FIRE RISK MANAGEMENT, INC

Memo Report

From: W. Mark Cummings, P.E.
To: Mr. Skip Reske, IDC Construction, LLC
Mr. Greg Sams, IDC Construction, LLC
Subject: **Fire Protection and Life Safety Systems Review; ICW Renovation of the Westin Eastland Park Hotel in Portland, ME**

**GROUND & 2ND LEVEL LIFE SAFETY PLANS**

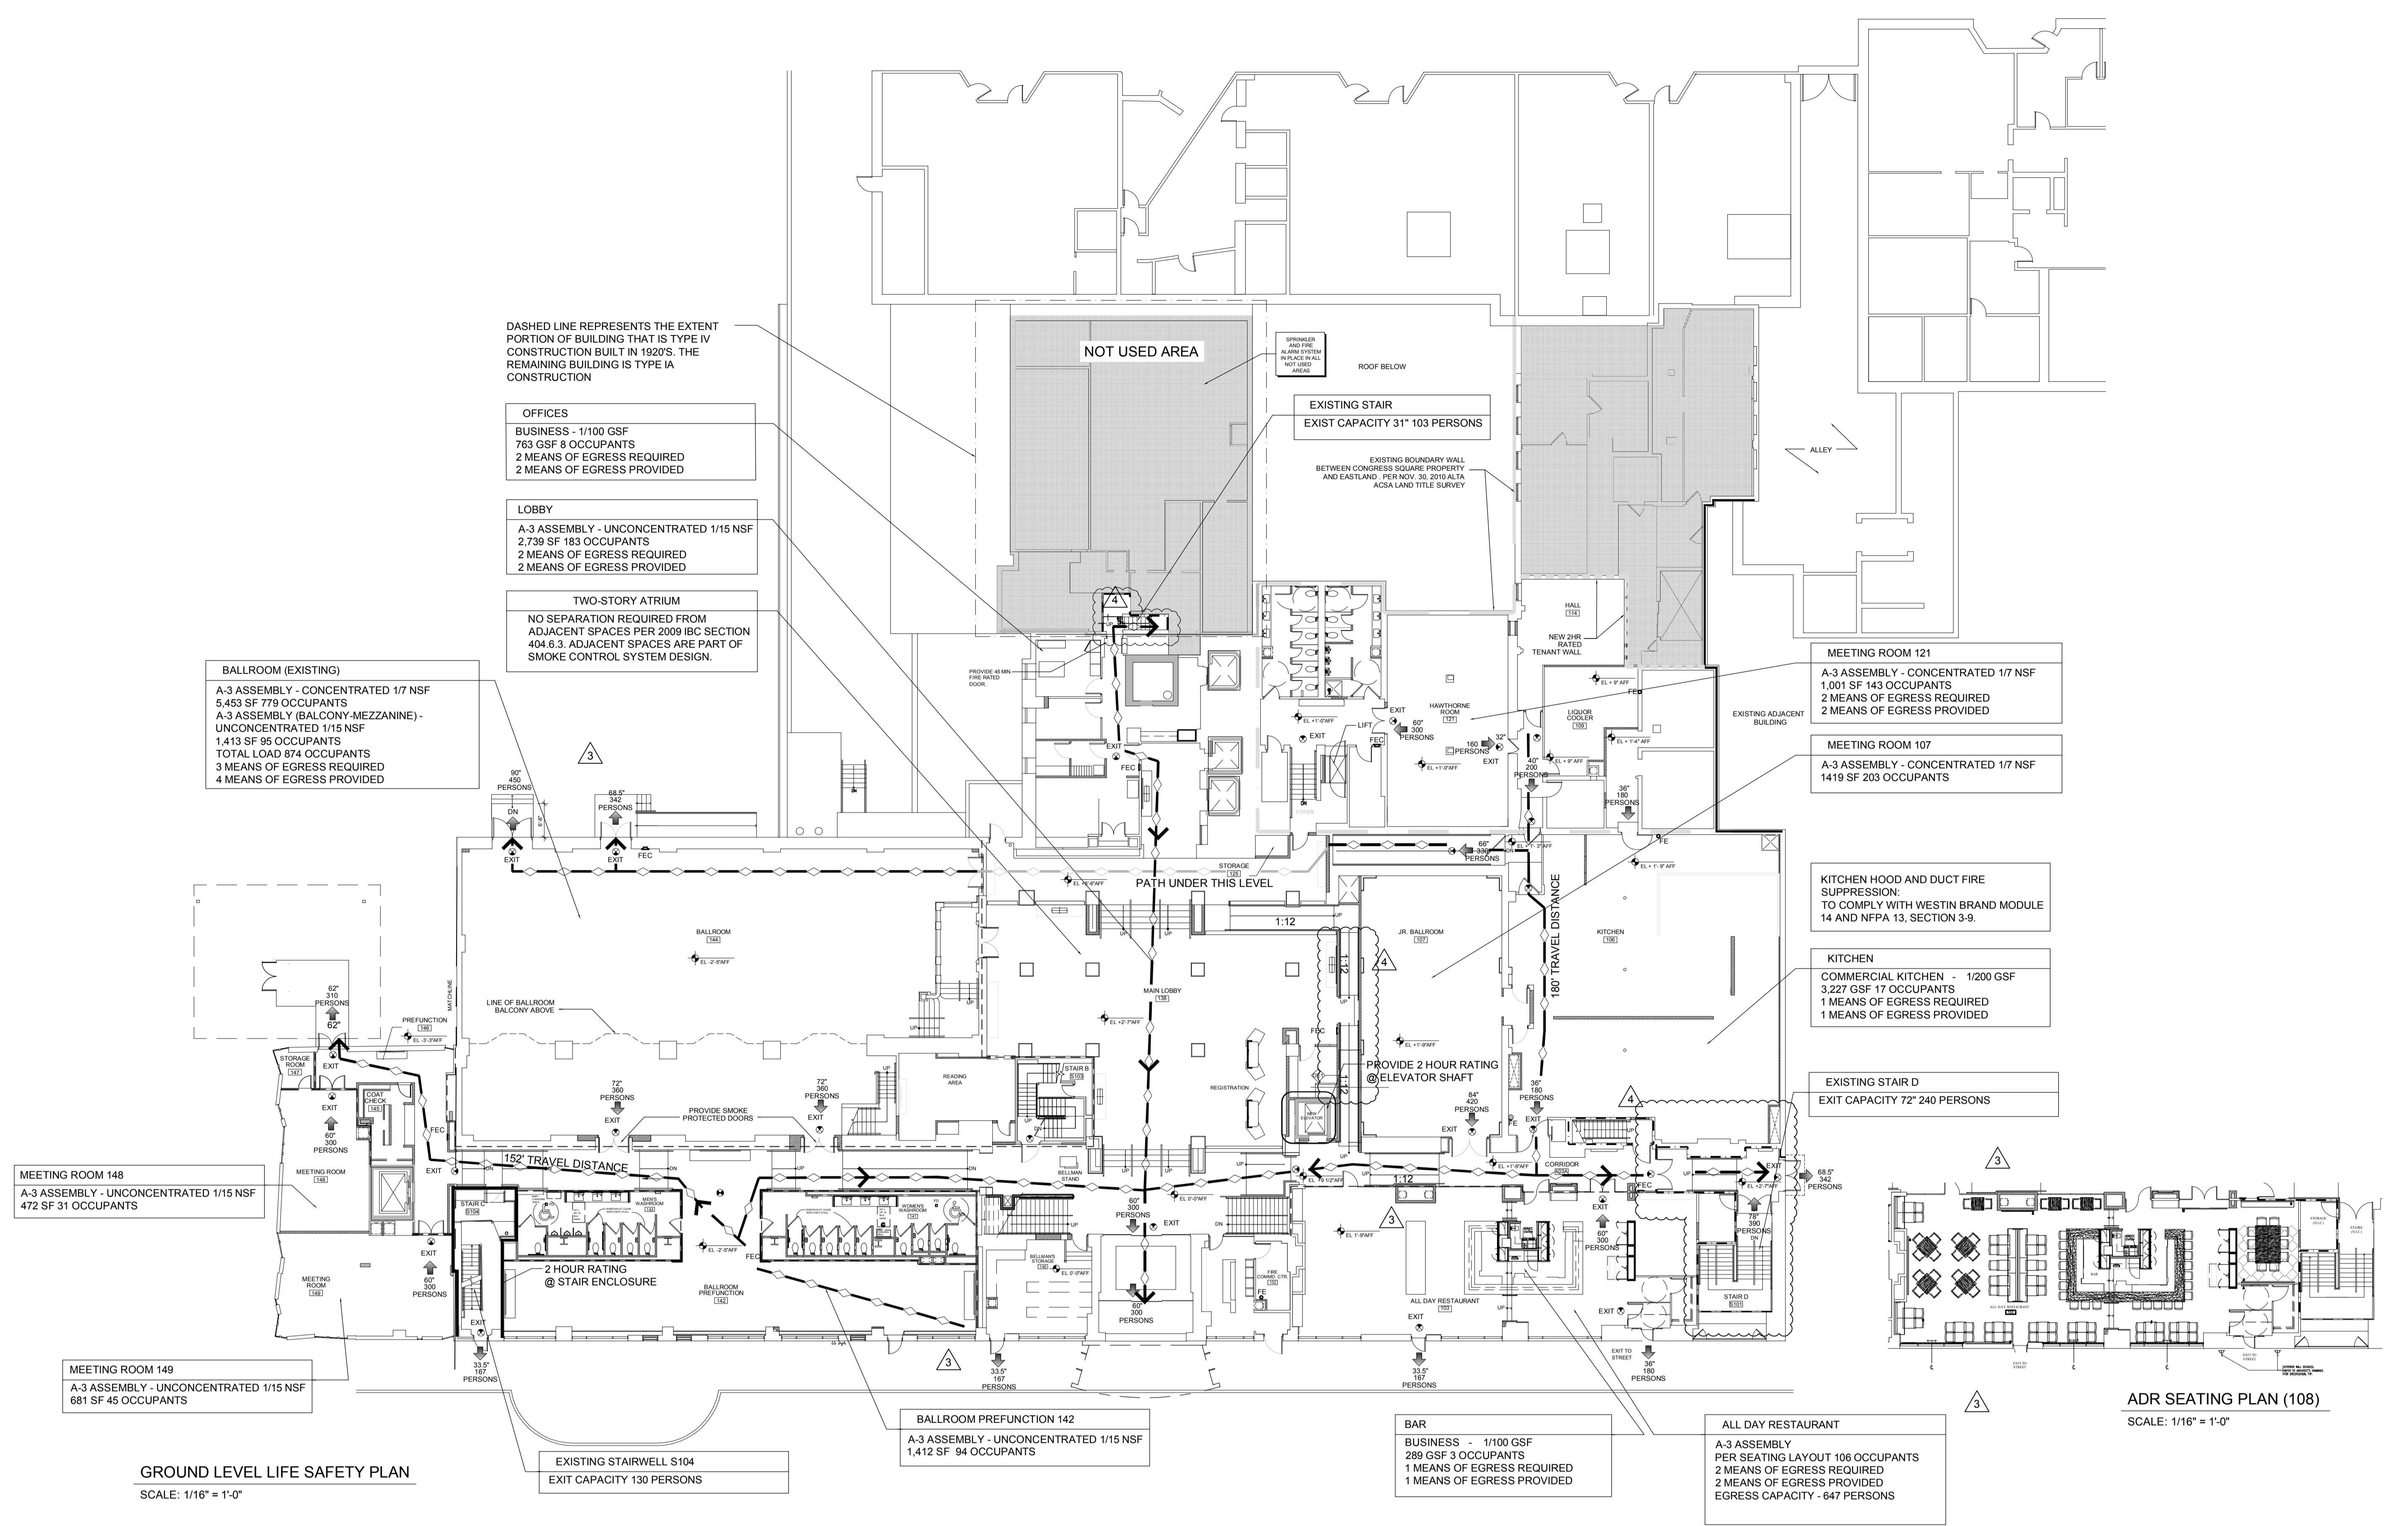
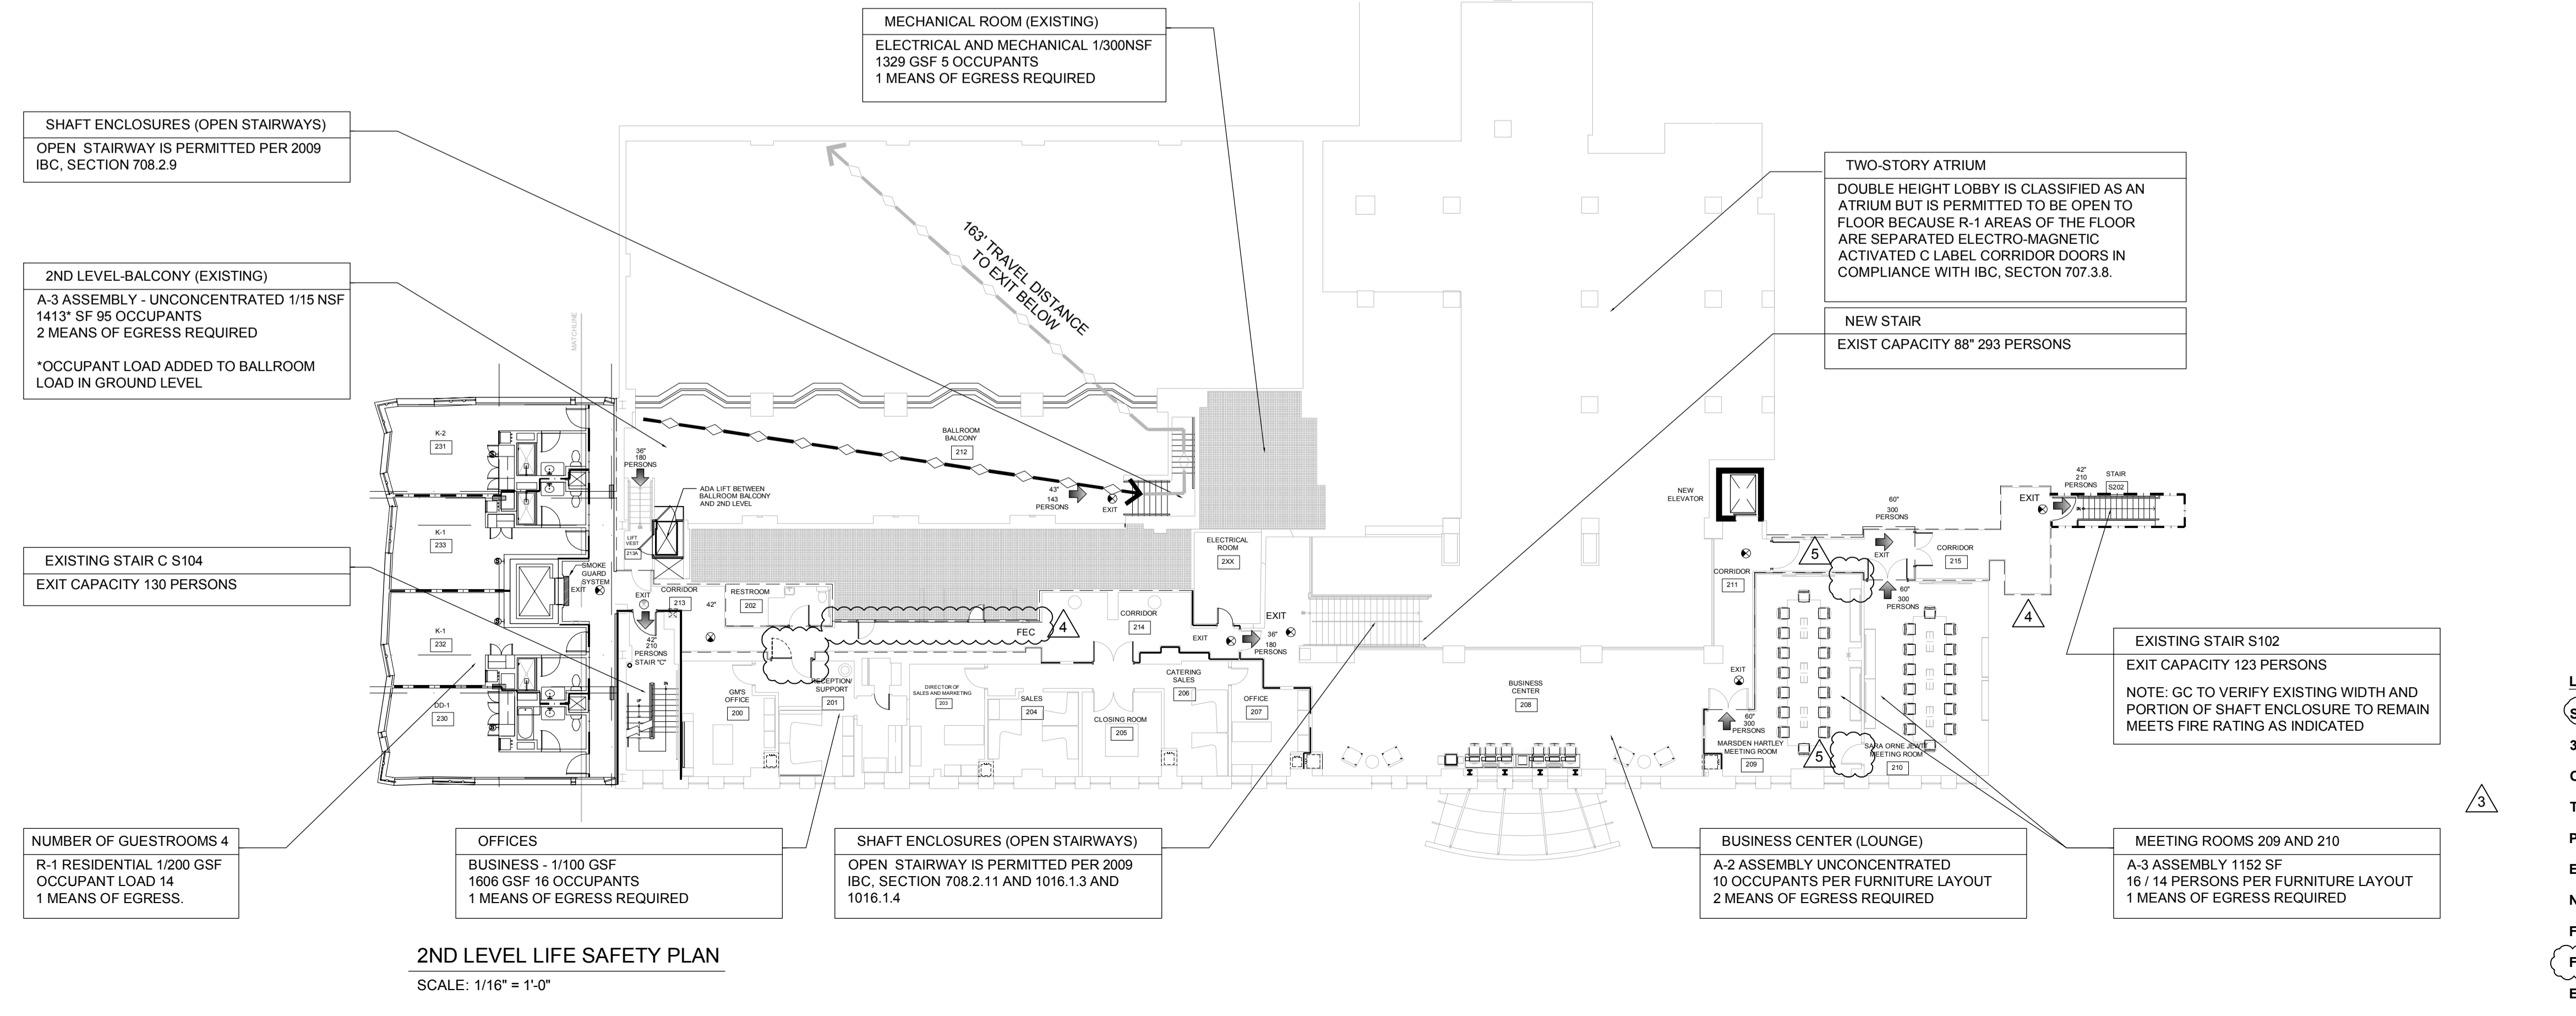
1. Need to add an exit sign within the “Prefunction” area at the 1st floor; adjacent to the exit door leading to the exterior, adjacent to High St.
2. Need to add an exit sign at the end of the ramp/corridor that acts as the second means of egress from the Junior Ballroom, connecting this room to the corridor adjacent to the ADR.
3. Need to relocate the exit sign that is adjacent to the Kitchen’s exit door and that leads to the service corridor for the Ballroom. This corridor also acts as a second means of egress from the Hawthorne (conference) Room and the current location of the exit sign is confusing. It should be moved to the center of the corridor and be

As soon as each item was identified during this final survey, IDC took immediate action to implement the necessary corrective actions.

14TH FLOOR LIFE SAFETY PLAN  
SCALE: 1/16" = 1'-0"

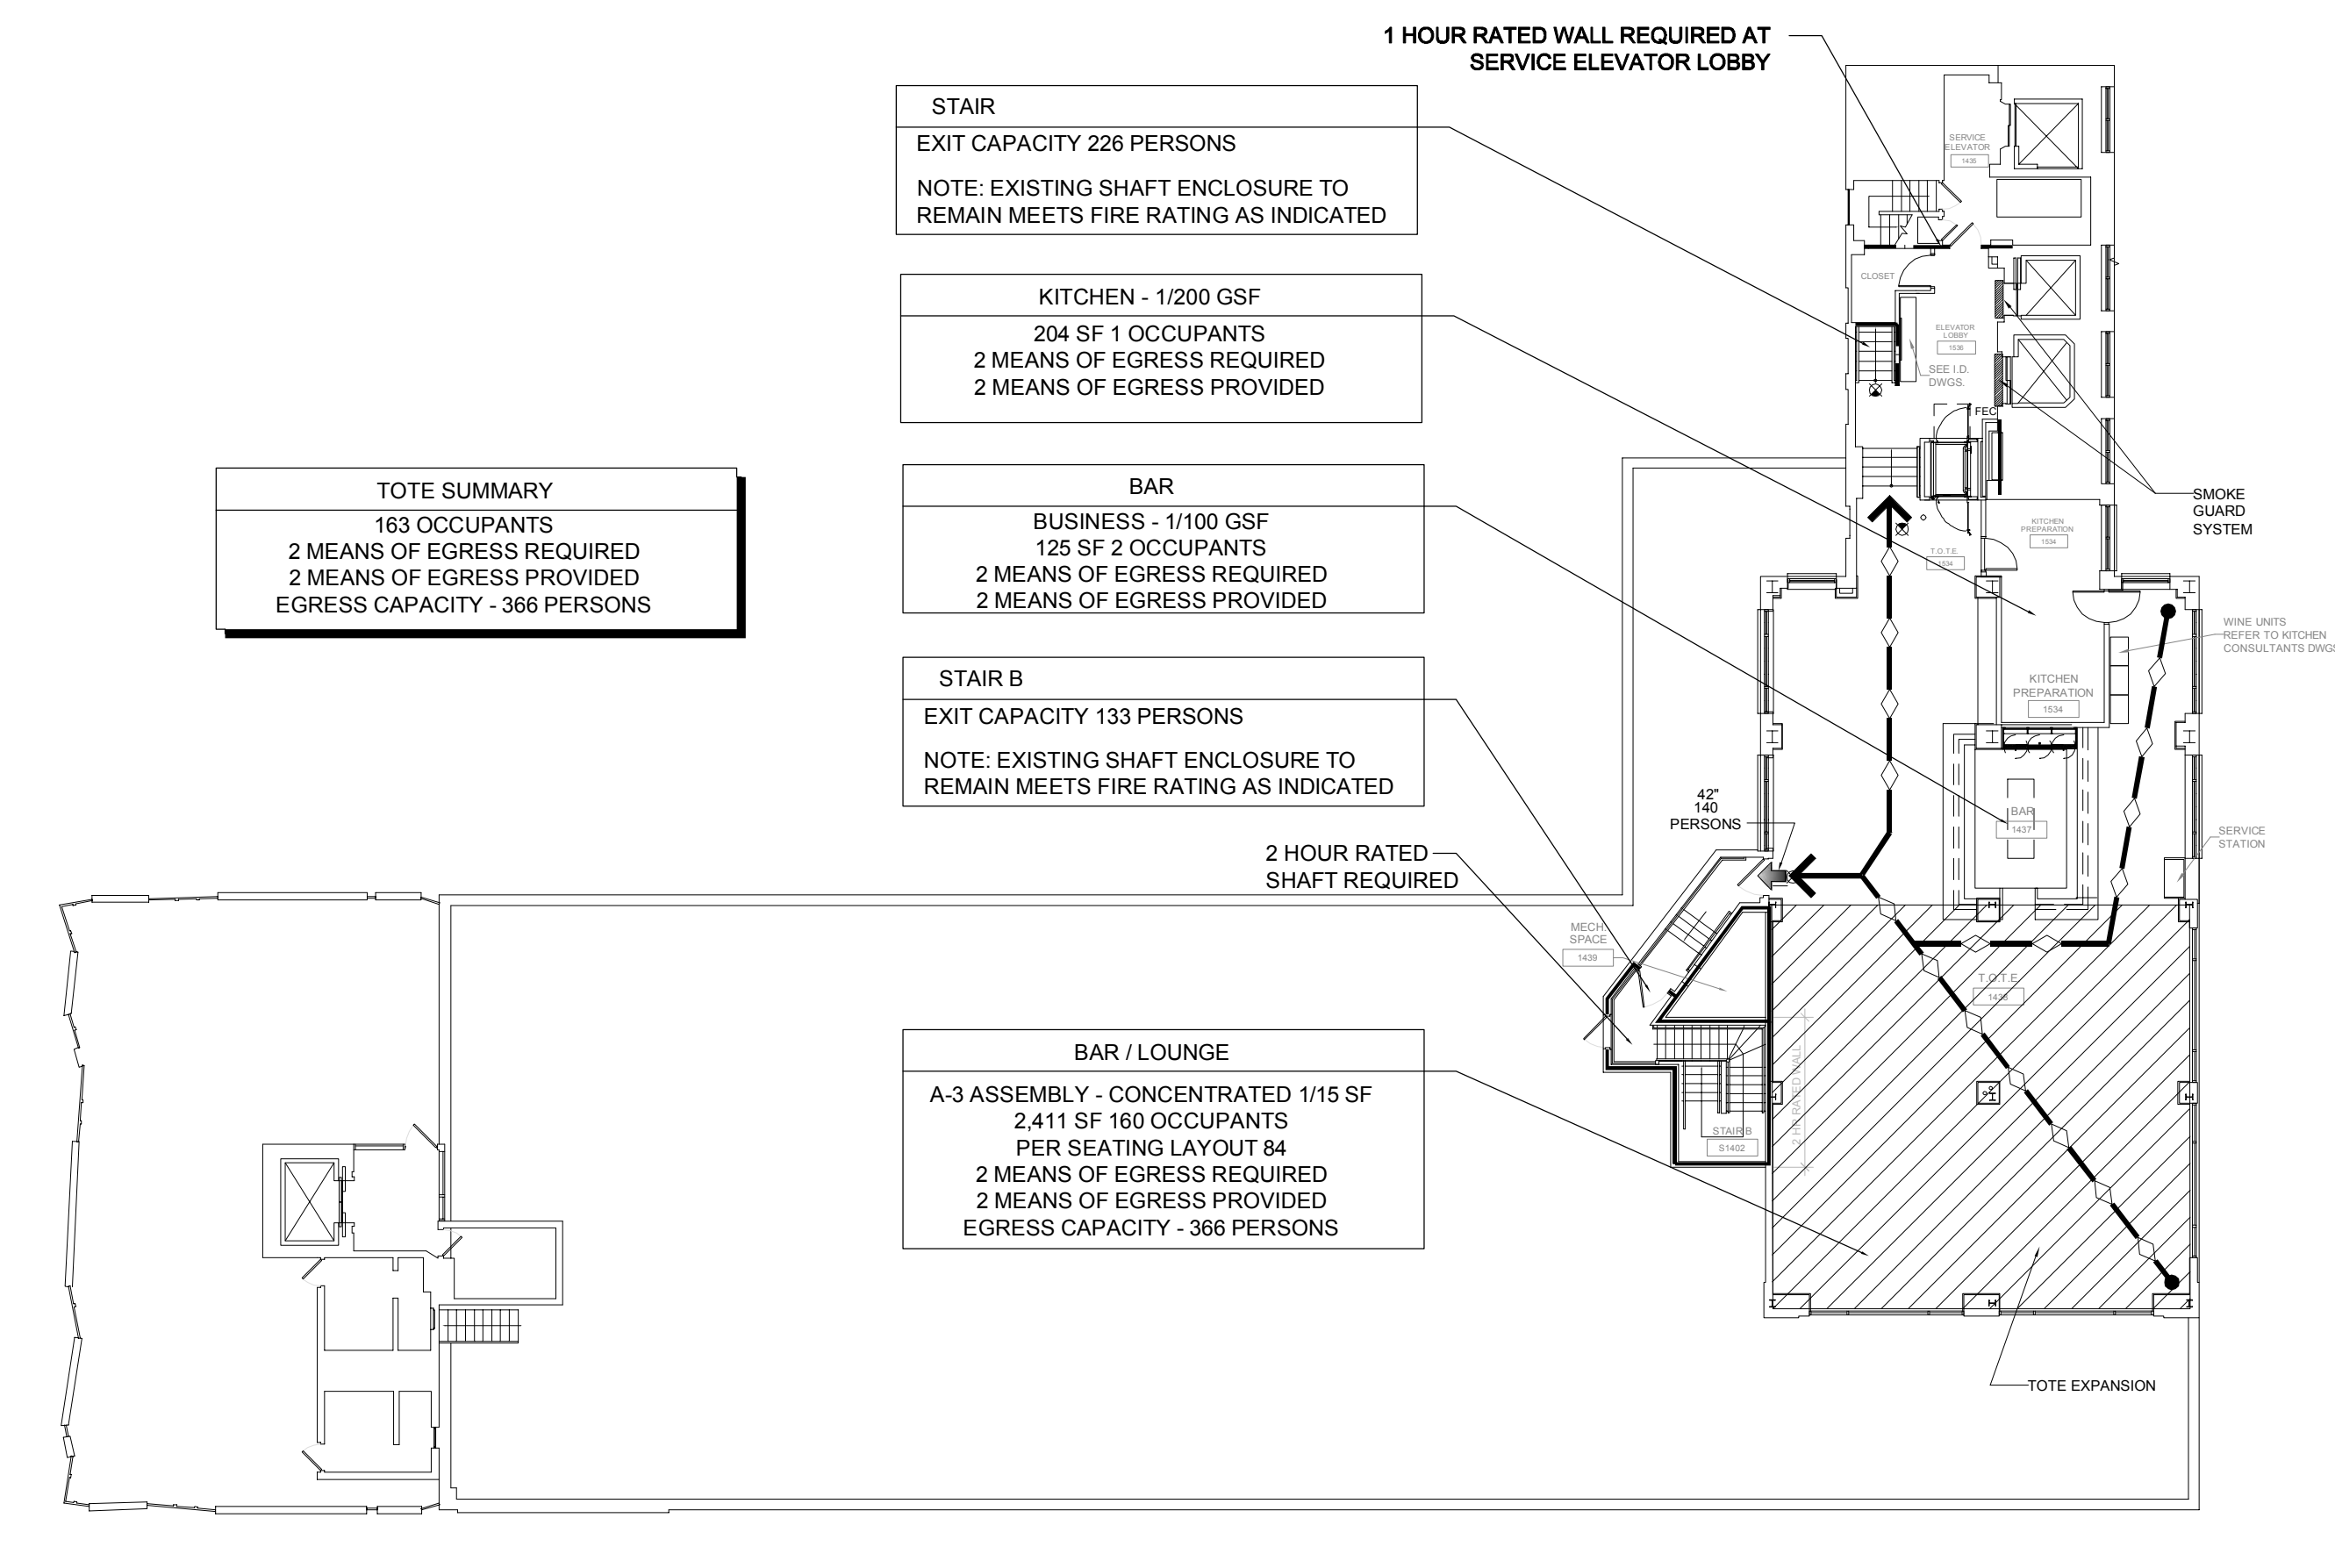
- designed such that it can be viewed from both the Kitchen side and the corridor from the Hawthorne Room; with arrows (chevrons) pointing in the direction of the Ballroom.
4. Provide continuity of the railing design for the stairway leading from the TOTE to the 14th floor to ensure that no gap in the railing exceeds 4 inches.
 5. Provide continuity of the railing design at the 1st floor level of Stair B to ensure no gap in the railing exceeds 4 inches.
 6. An exit sign should be added to the inside of the 1st floor door in Stair B to highlight the fact that this is the level of exit discharge for this stair.
